SUBJECT: Engineering Review Comment
Mountain View Electric Association Inc. (MVEA)

Project Name: Falcon Reserve Final Plat

Project Number: SF2617

Description: Proposed development of 149 residential lots and 7 tracts located at Meridian Rd. and Stapleton Dr. in Township 12S, Range 65W, Section 25.

SHEET 3 OF 4

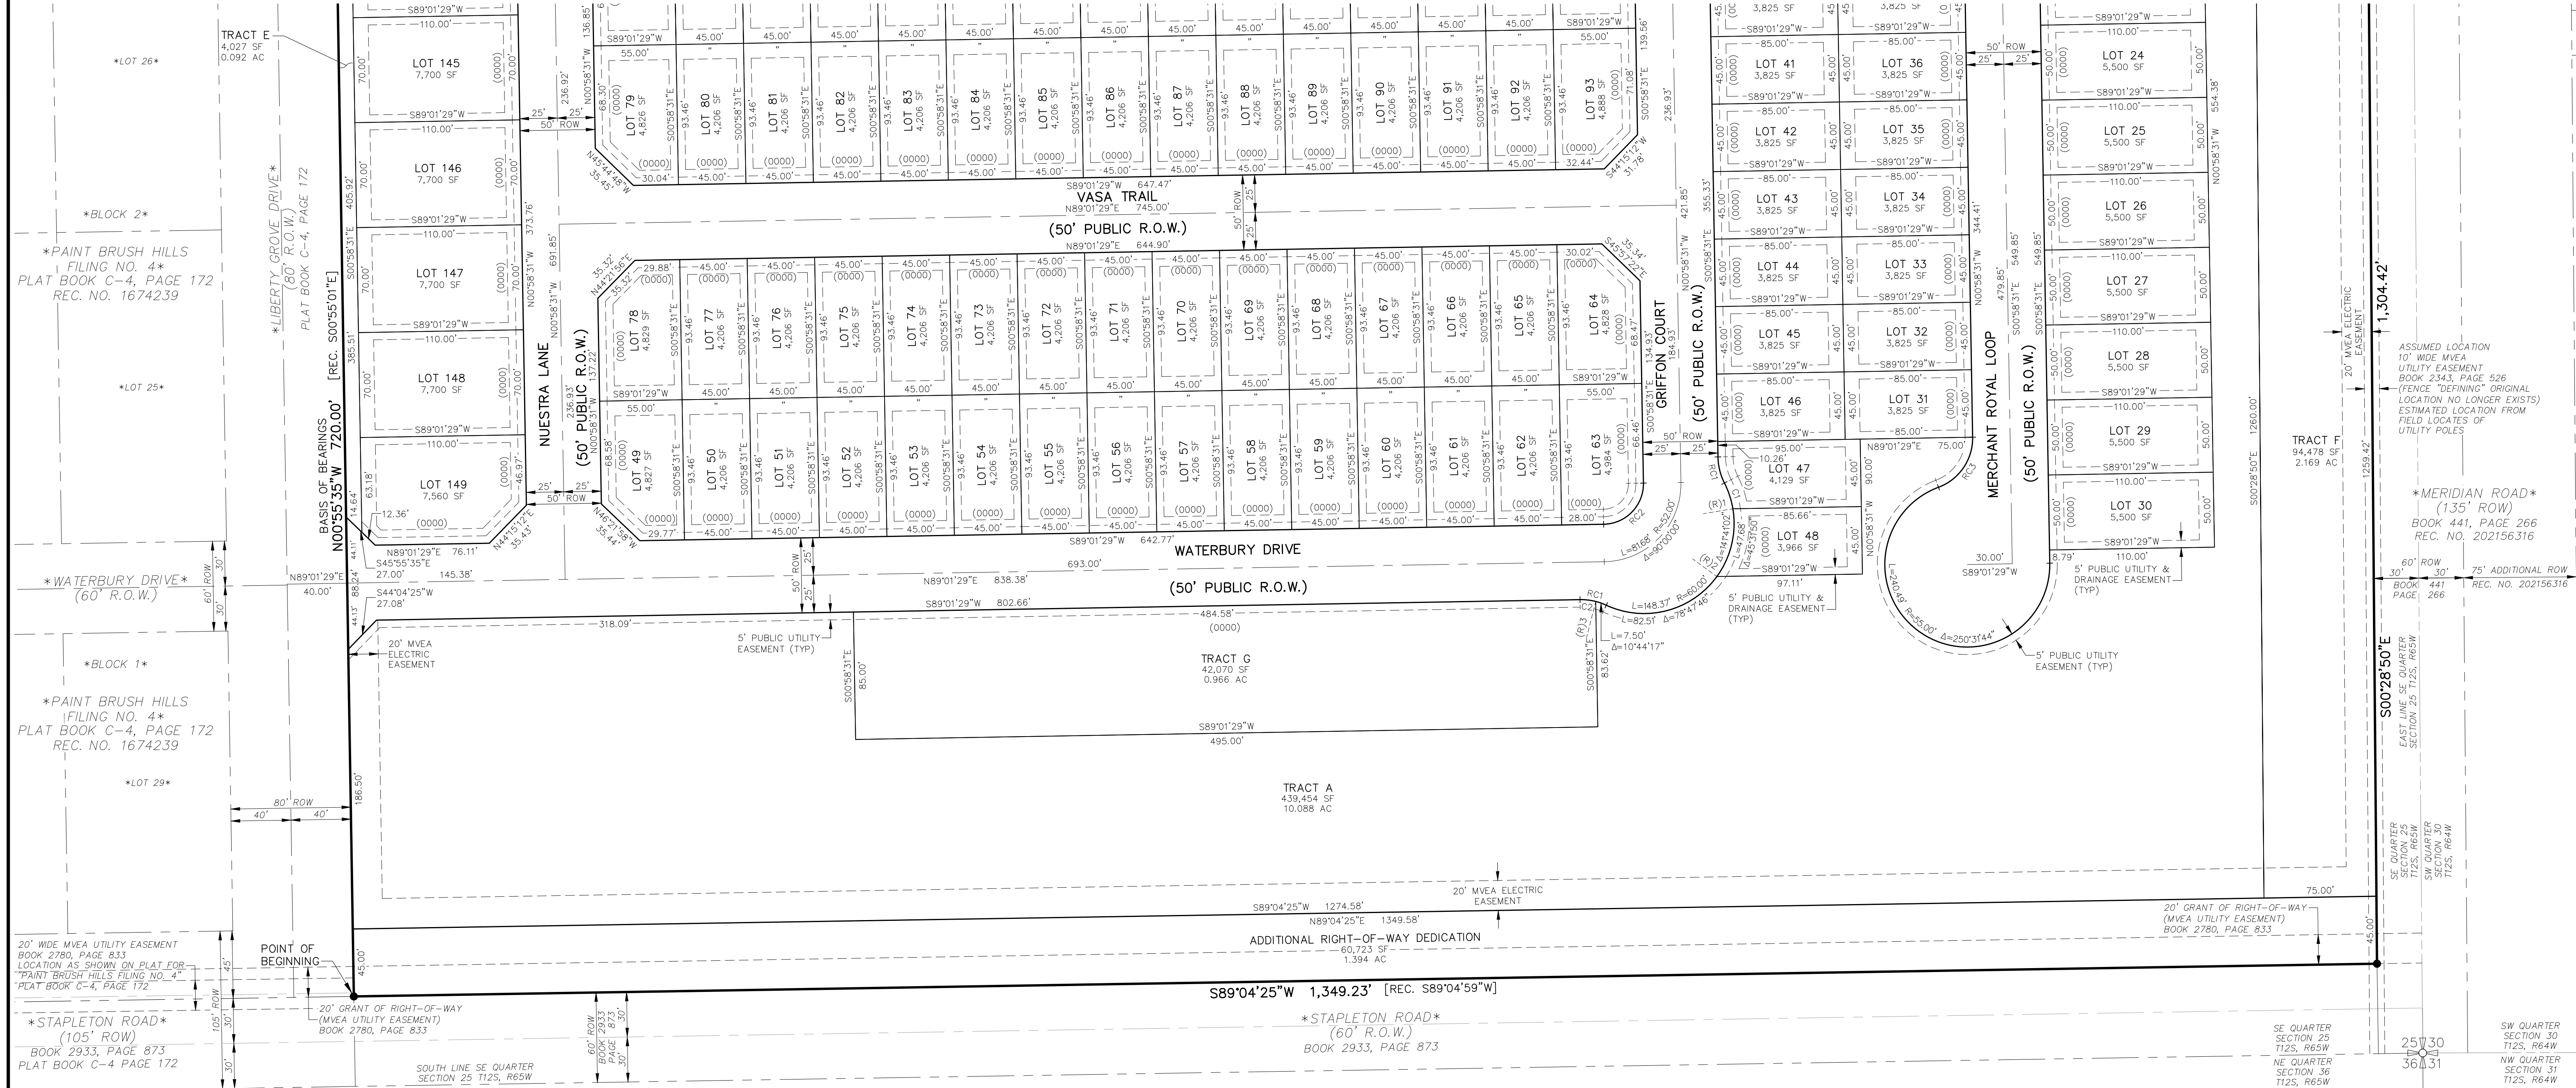
MVEA requests a ten (10) foot front lot utility easement, a five (5) foot side lot utility easement, and a ten (10) foot rear lot utility easement along with a twenty (20) foot exterior utility easement on the plat and all tracts include easements. MVEA also requests the platting of MVEA's existing facilities with easements on the plat. Additional easements may be required.
